CITY OF ALBUQUERQUE

August 10, 2017

RE: **Heritage Marketplace Tract C3**
1720 Unser Blvd
Conceptual Grading and Drainage Plan
Engineer's Stamp Date 8/7/17 (File: H09D027)

PROJECT TITLE HERITAGE MARKET PLACE - TRACT C-3 1720 UNSER BLVD NW ALBUQUERQUE, NEW MEXICO 87120	DRAWN BY: JEFF WOOTEN
PROJECT MANAGER JEFF WOOTEN	JOB NO. 2016029
SHEET TITLE Grading Plan	SHEET NO. 2

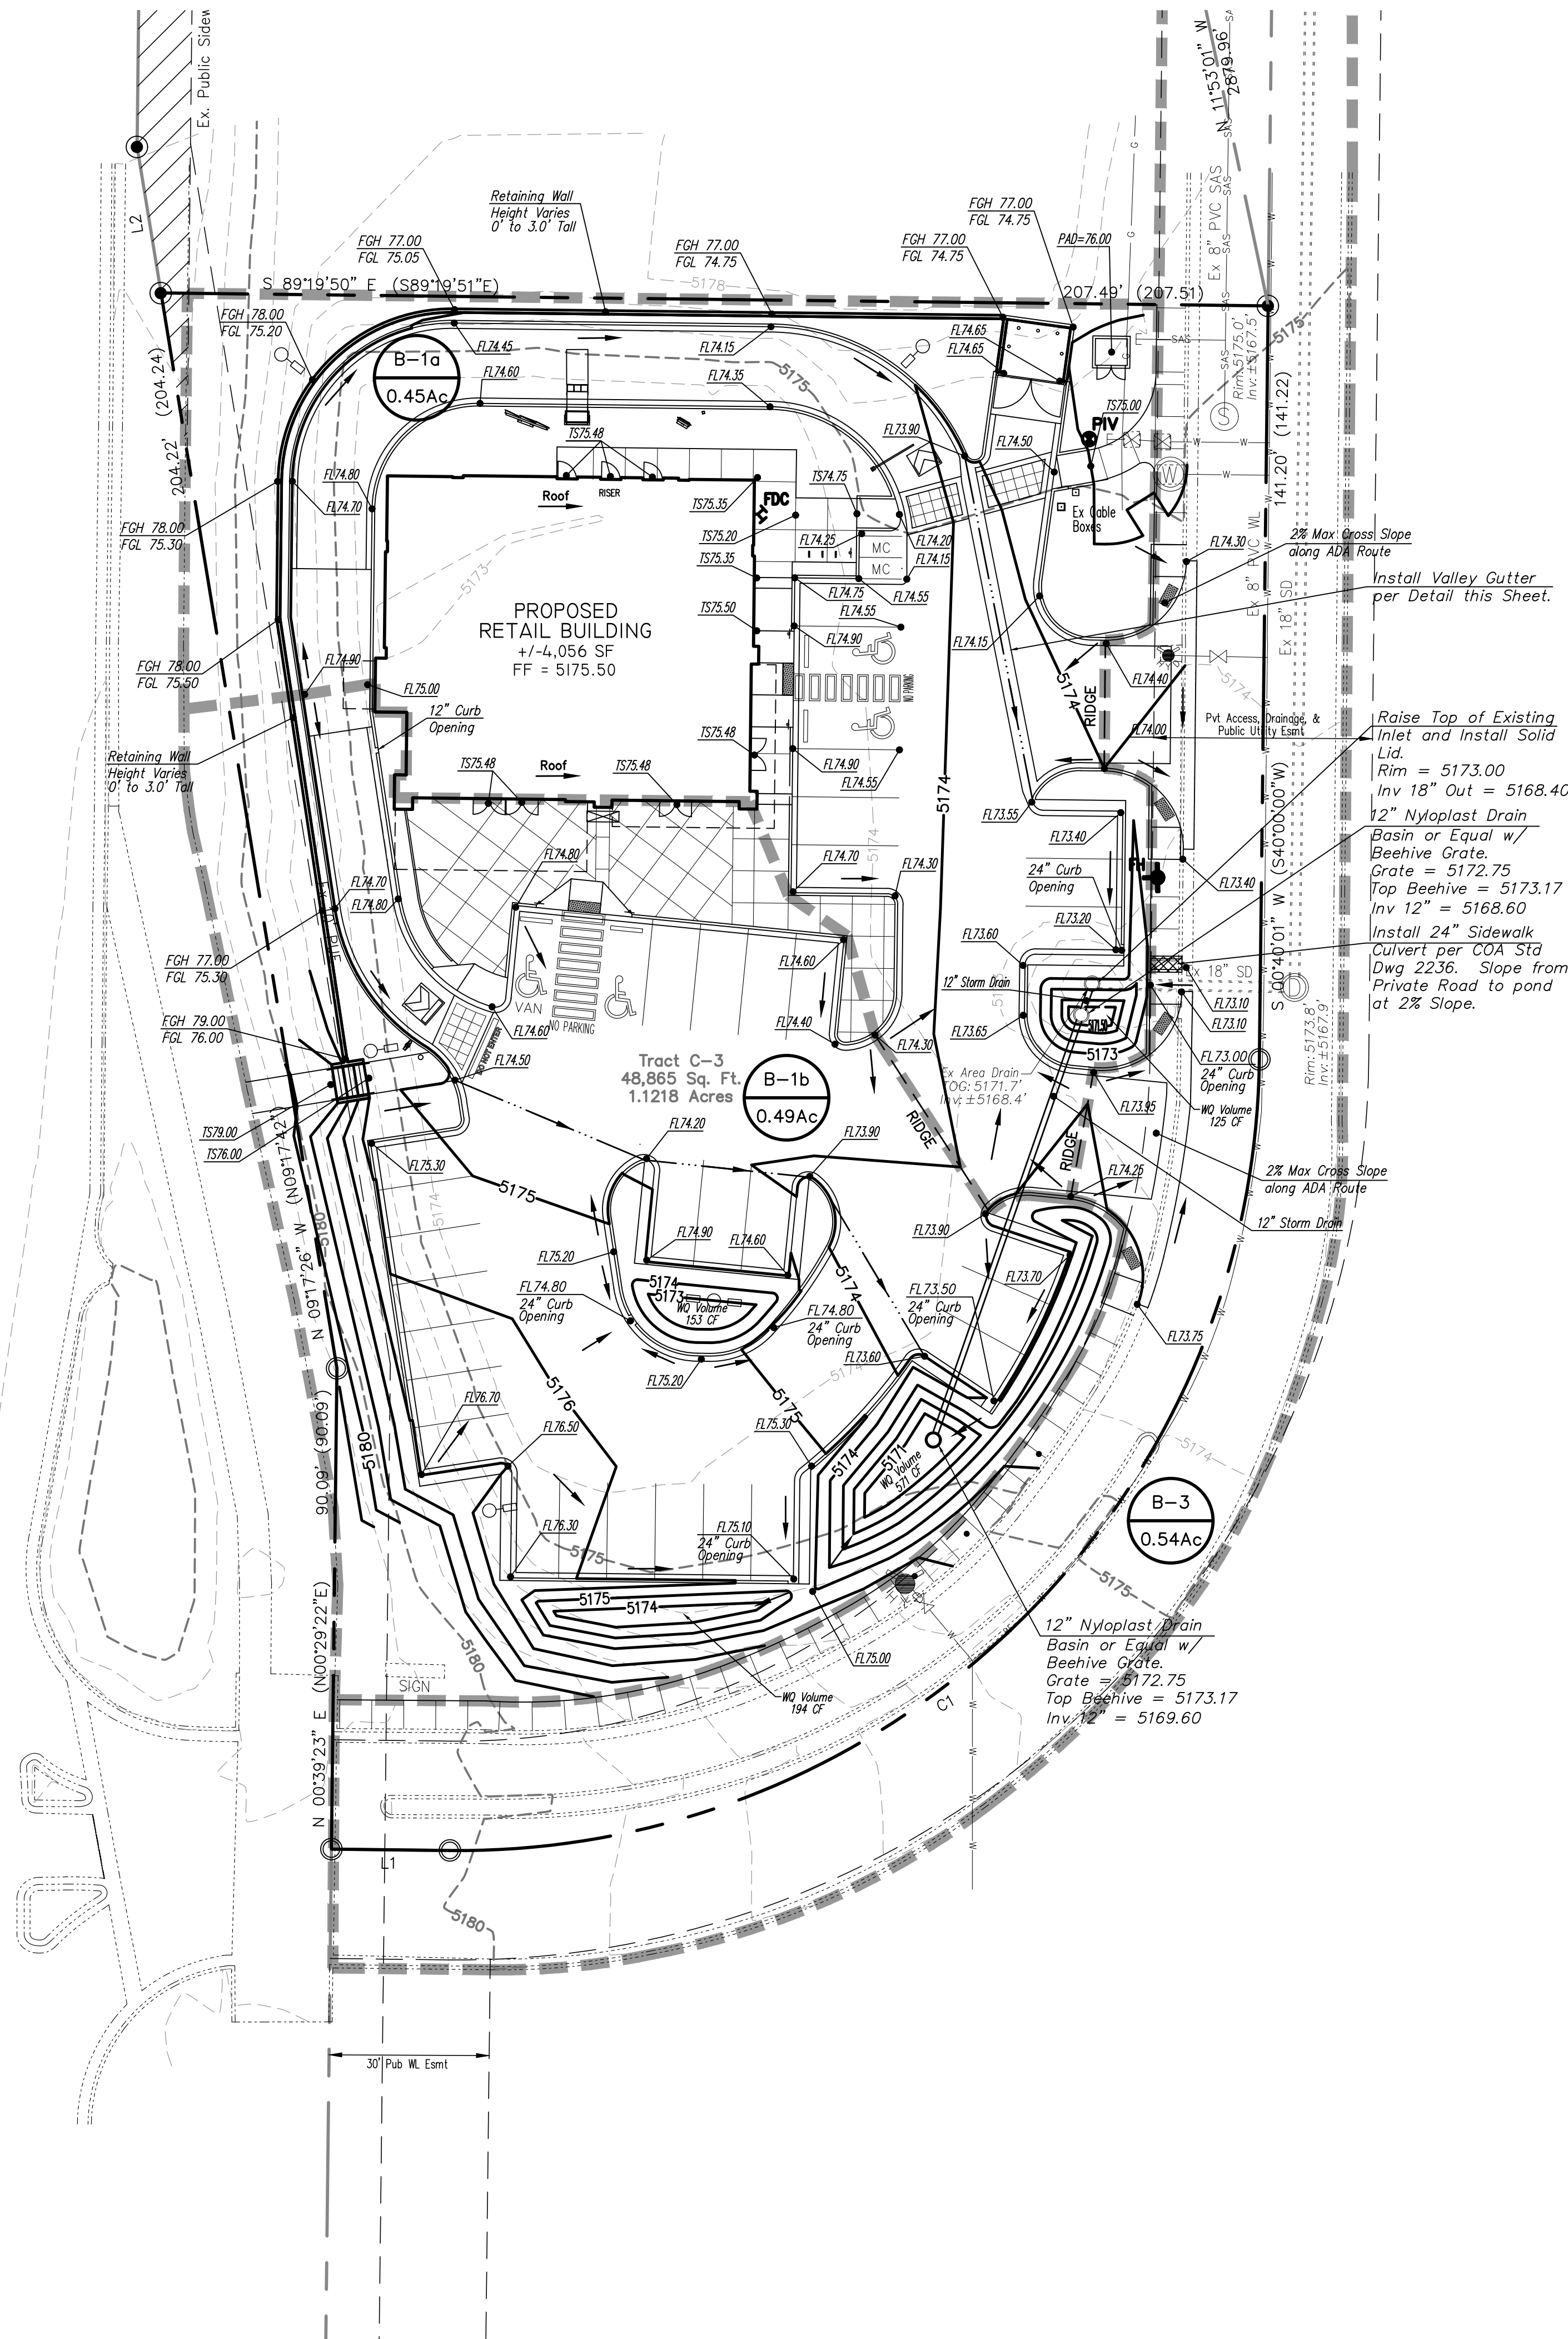
1. It appears that a 24" sidewalk culvert is required at the sump along the access road (FL=73.10) to drain the private road into the pond. If this is the case, provide appropriate callouts, labeling, and std detail references. If not, clarify how this area will drain to the pond.
2. A private facility drainage covenant is required on the ponds. As discussed in email, the original notarized form (with exhibit) will need to be turned into Madeline Carruthers (4th floor, mtafoya@cabq.gov) for signature routing.
